## **Boston Alternative Energy Facility**

Schedule of changes to the Draft Development Consent Order

Document Reference: 9.20

Date: 19 October 2021

TITLE  
 BOSTON ALTERNATIVE ENERGY FACILITY  
 DEVELOPMENT CONSENT ORDER  
 Regulation 5(2)(c) - Illustrative Landscape Plans  
 BOSTON BOROUGH COUNCIL  
 SHEET 1 OF 8

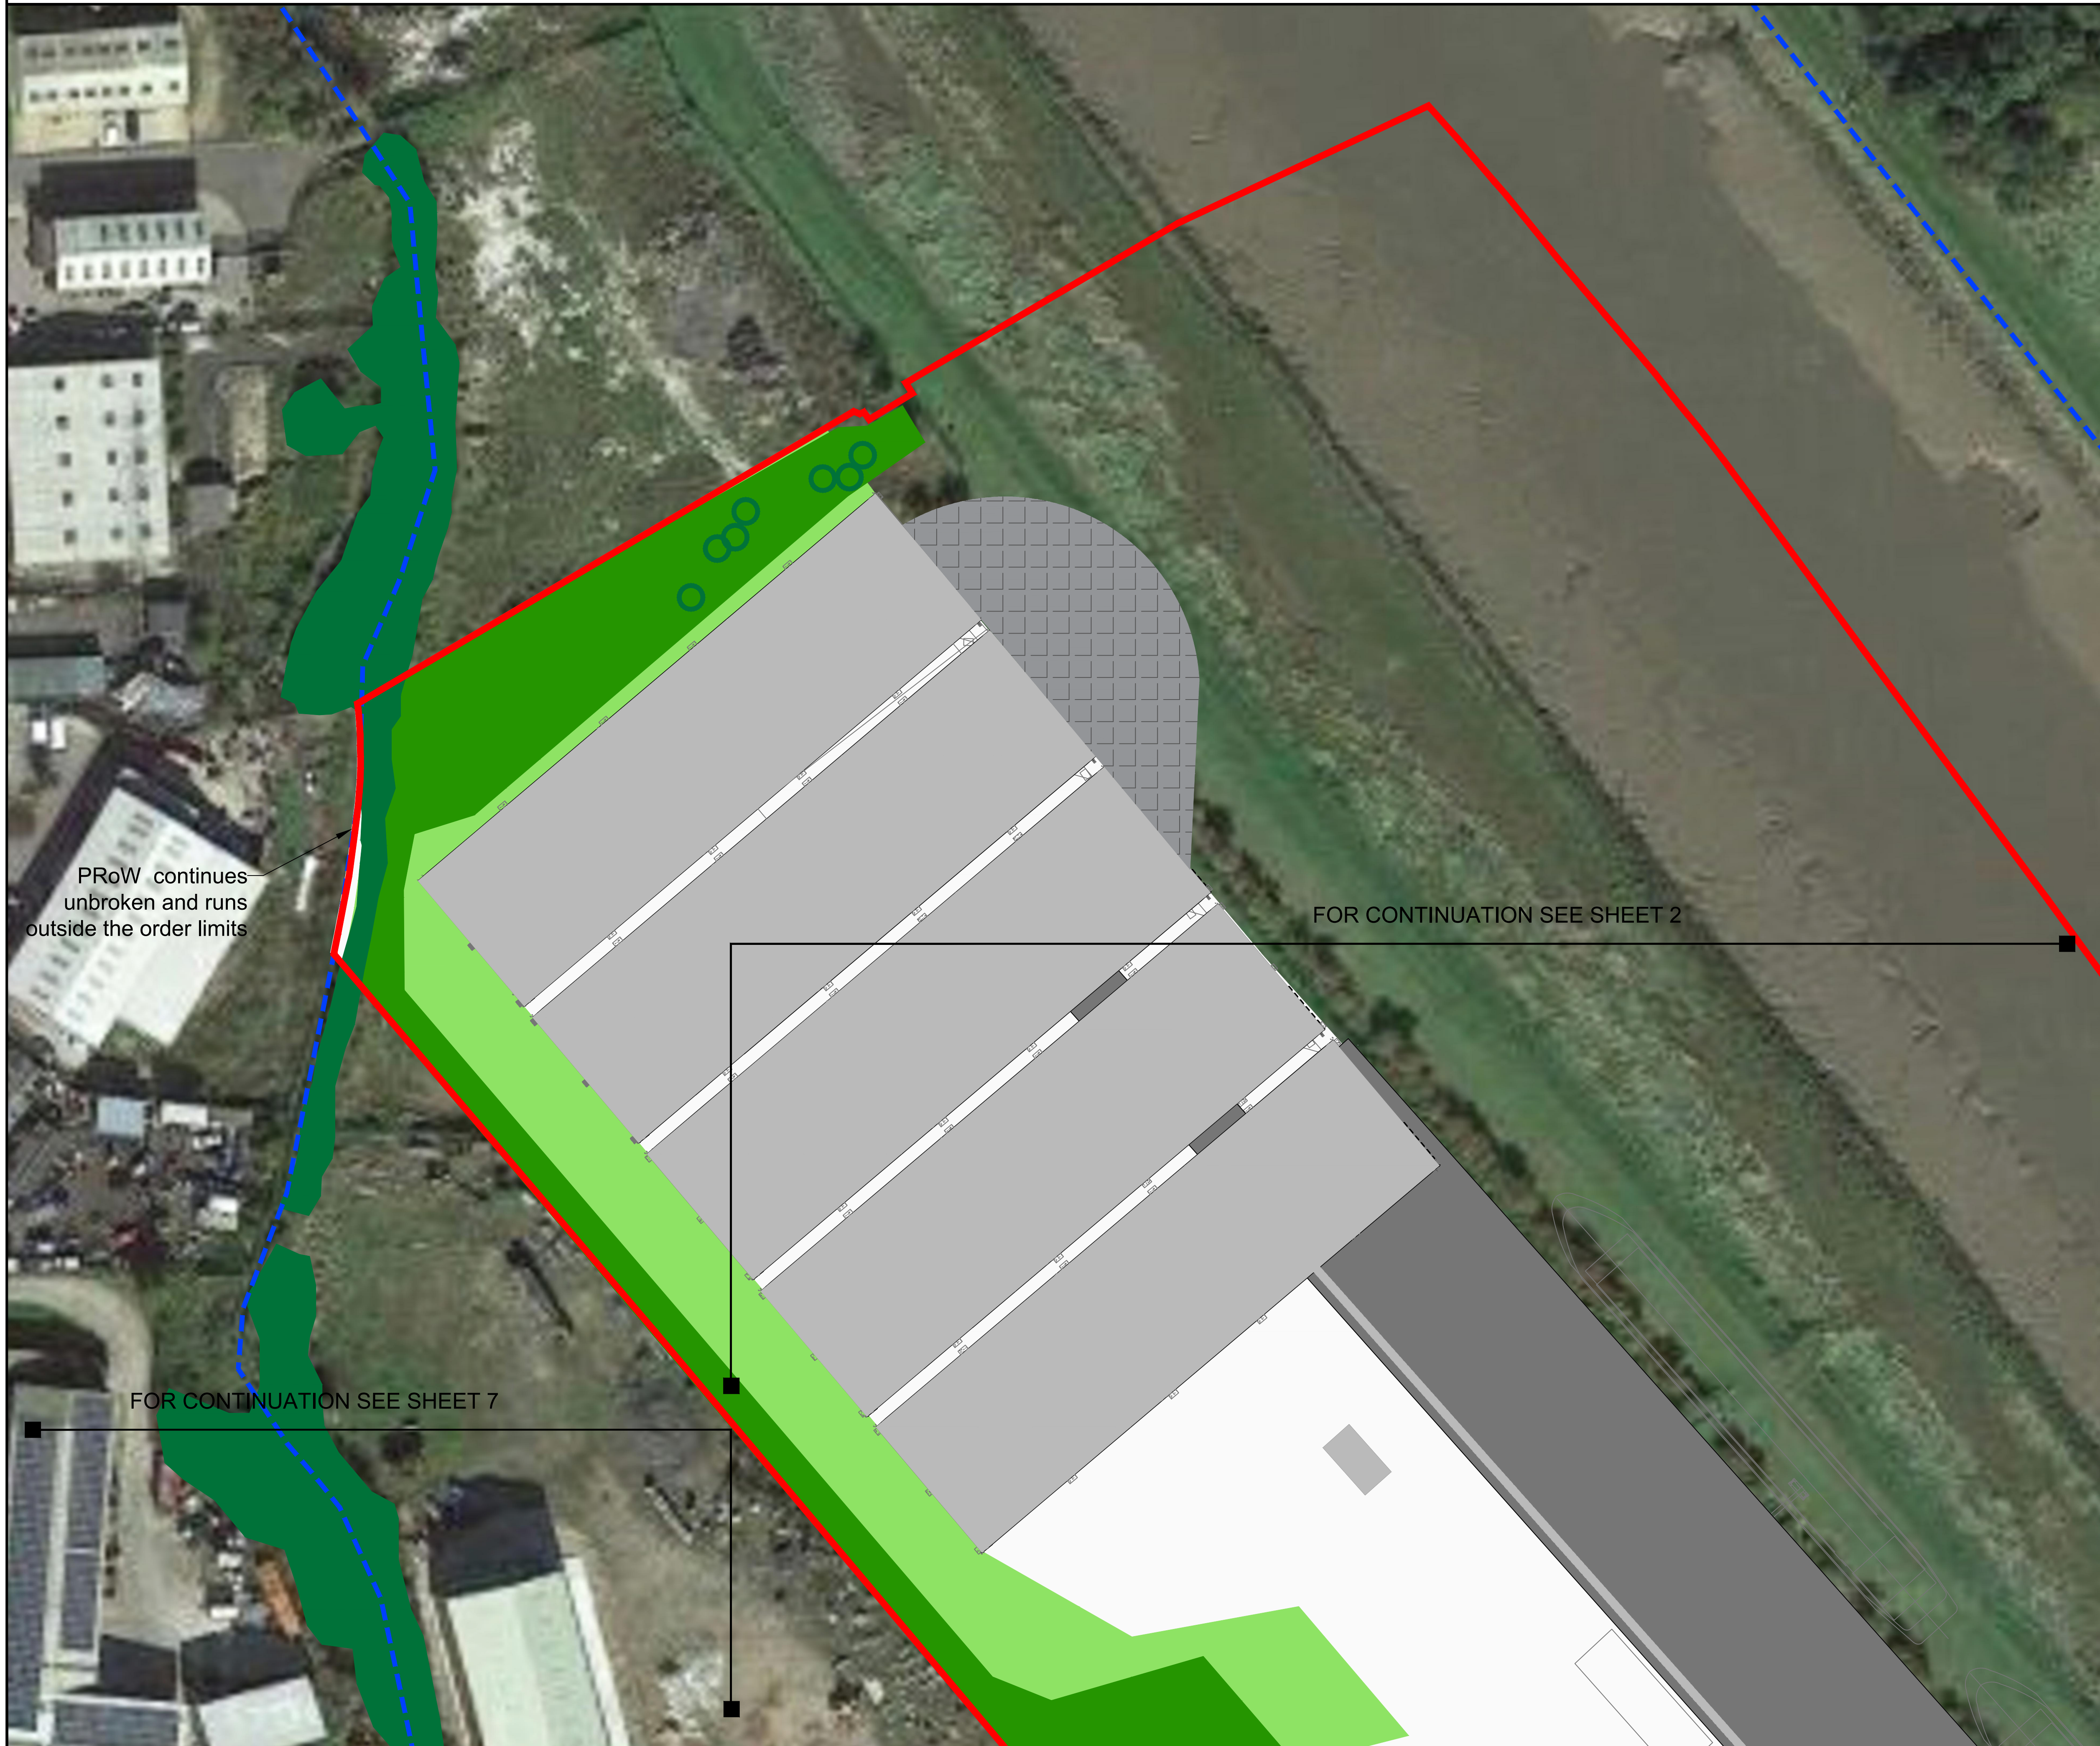
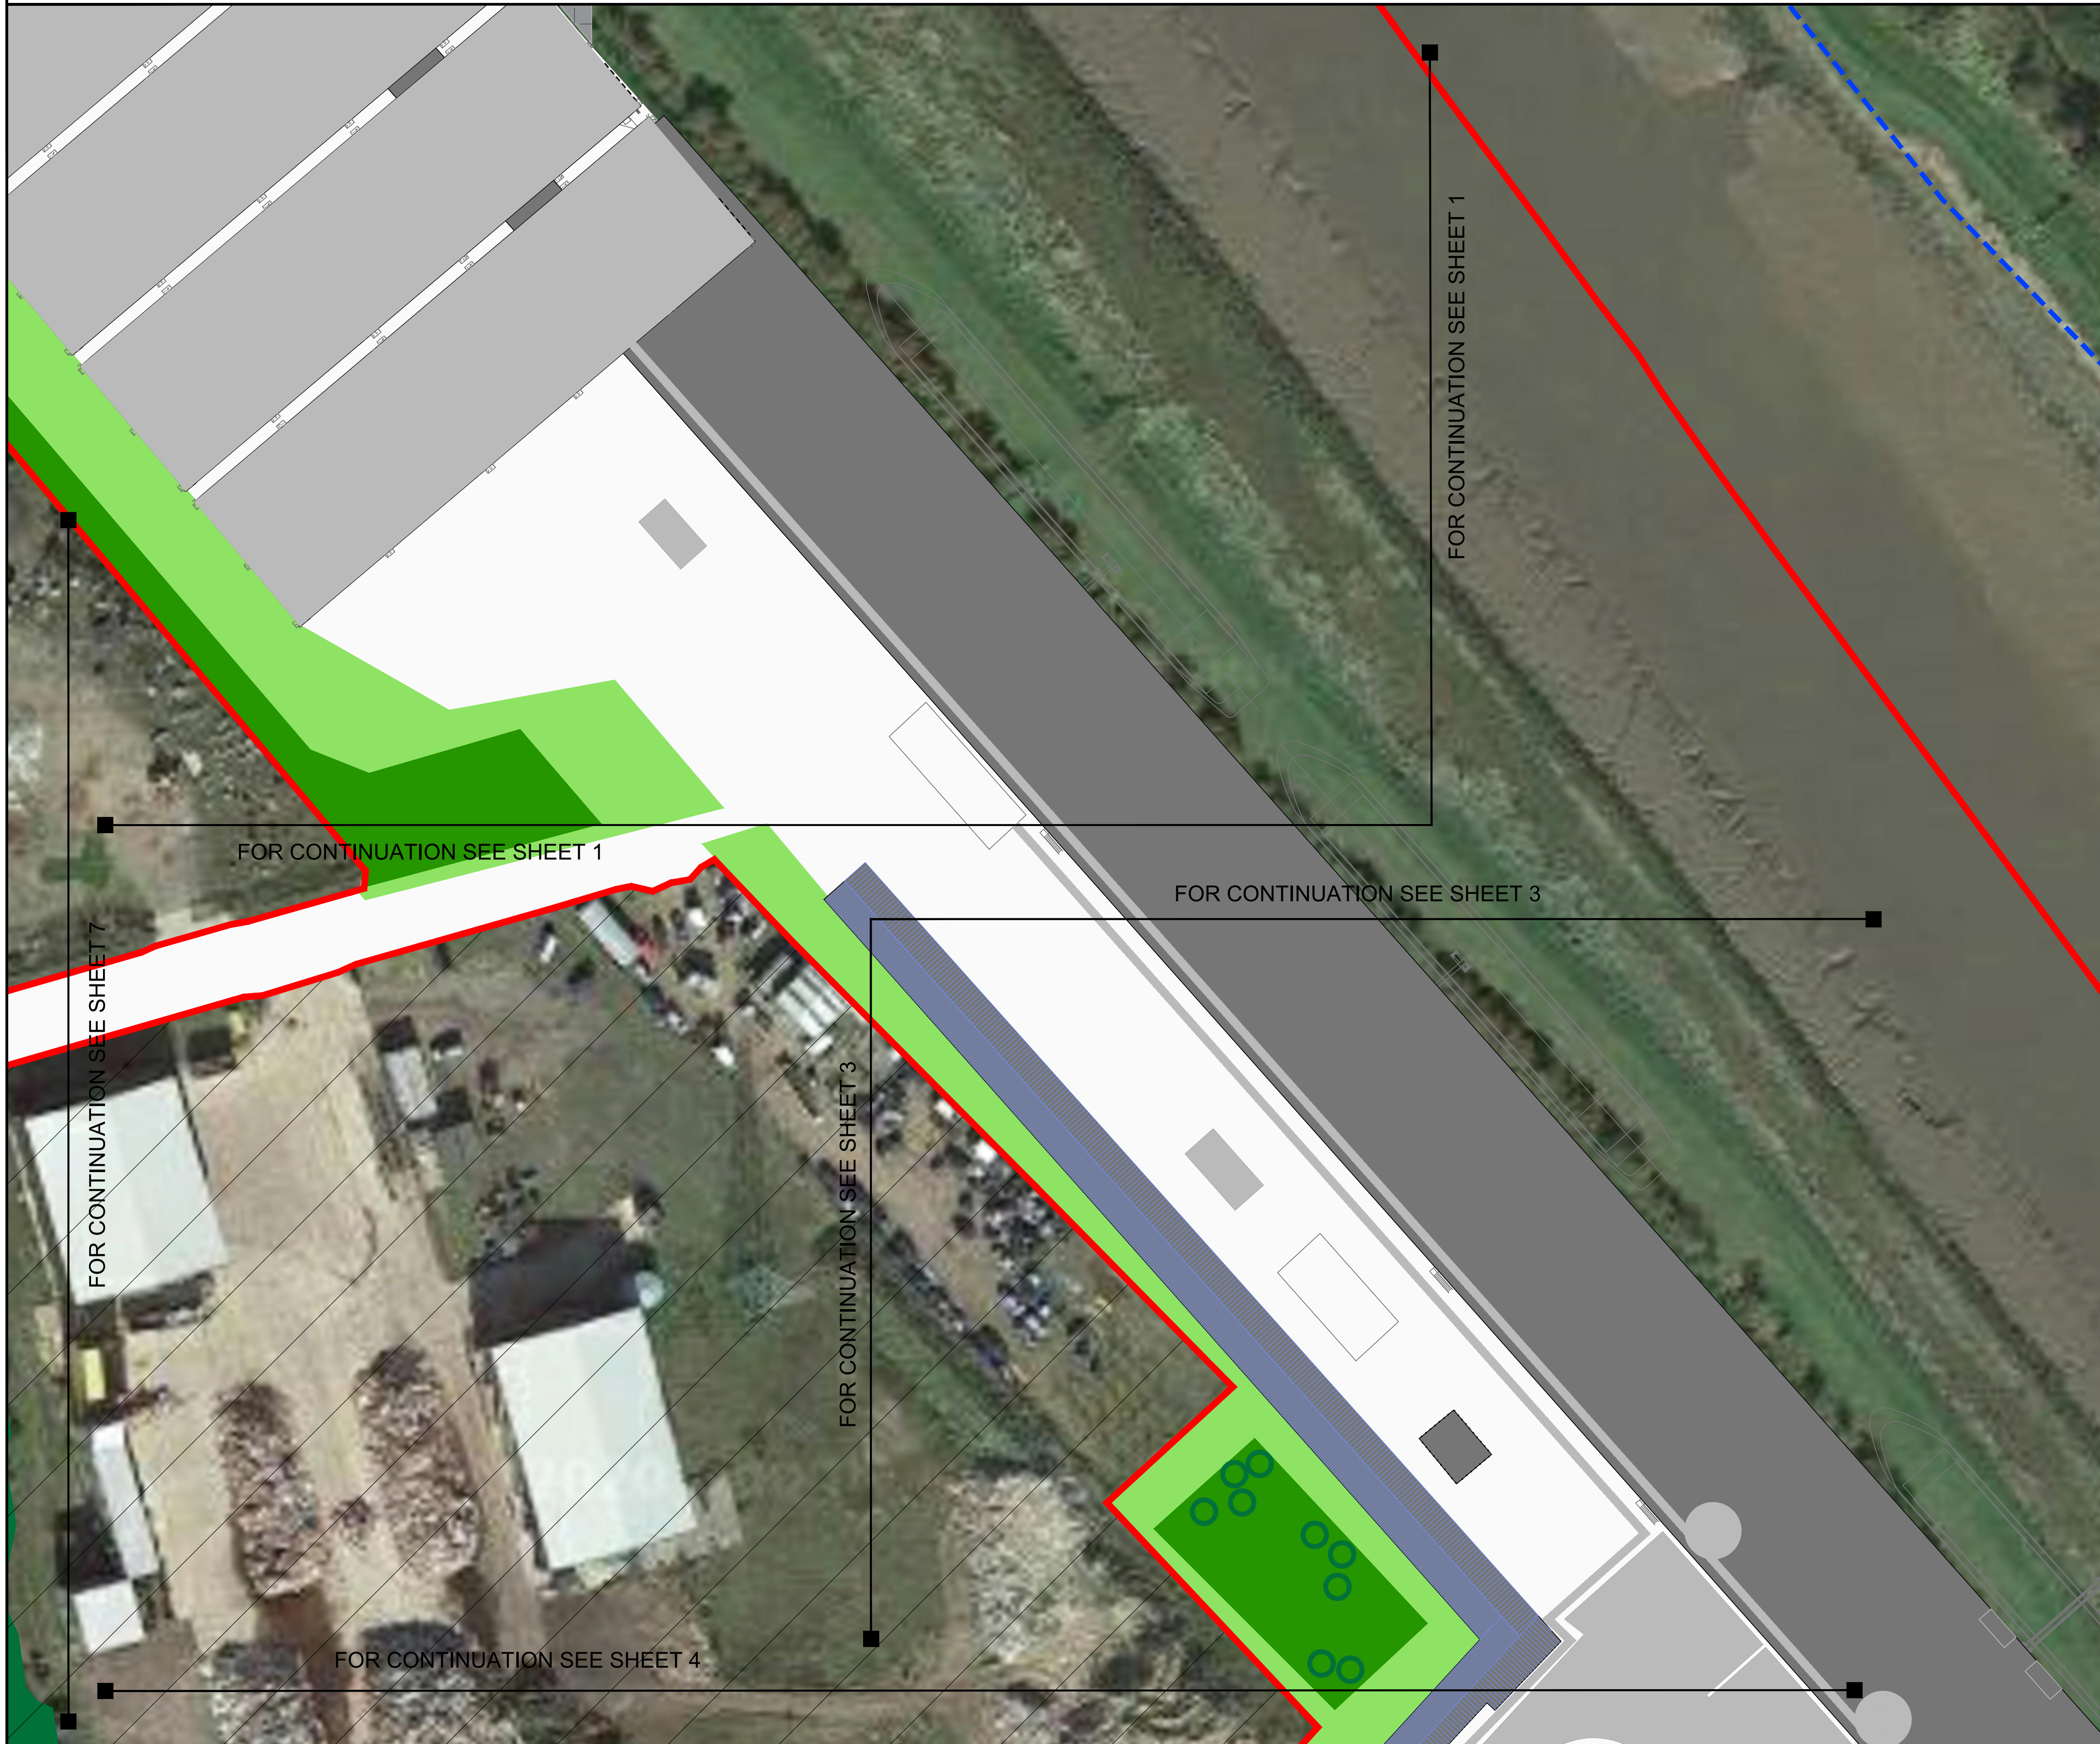
No.	Provision	Suggested amendment	Explanation for change
			Offshore Wind Farm Order 2020.
21.	Schedule 1, Work No. 6, Requirement (d)	(d) a footbridge spanning <del>footpaths BOST/14/11 and BOST/14/9 along the Roman Bank</del> to allow safe pedestrian passage over certain site roads; and	Correction to refer to footpath numbers
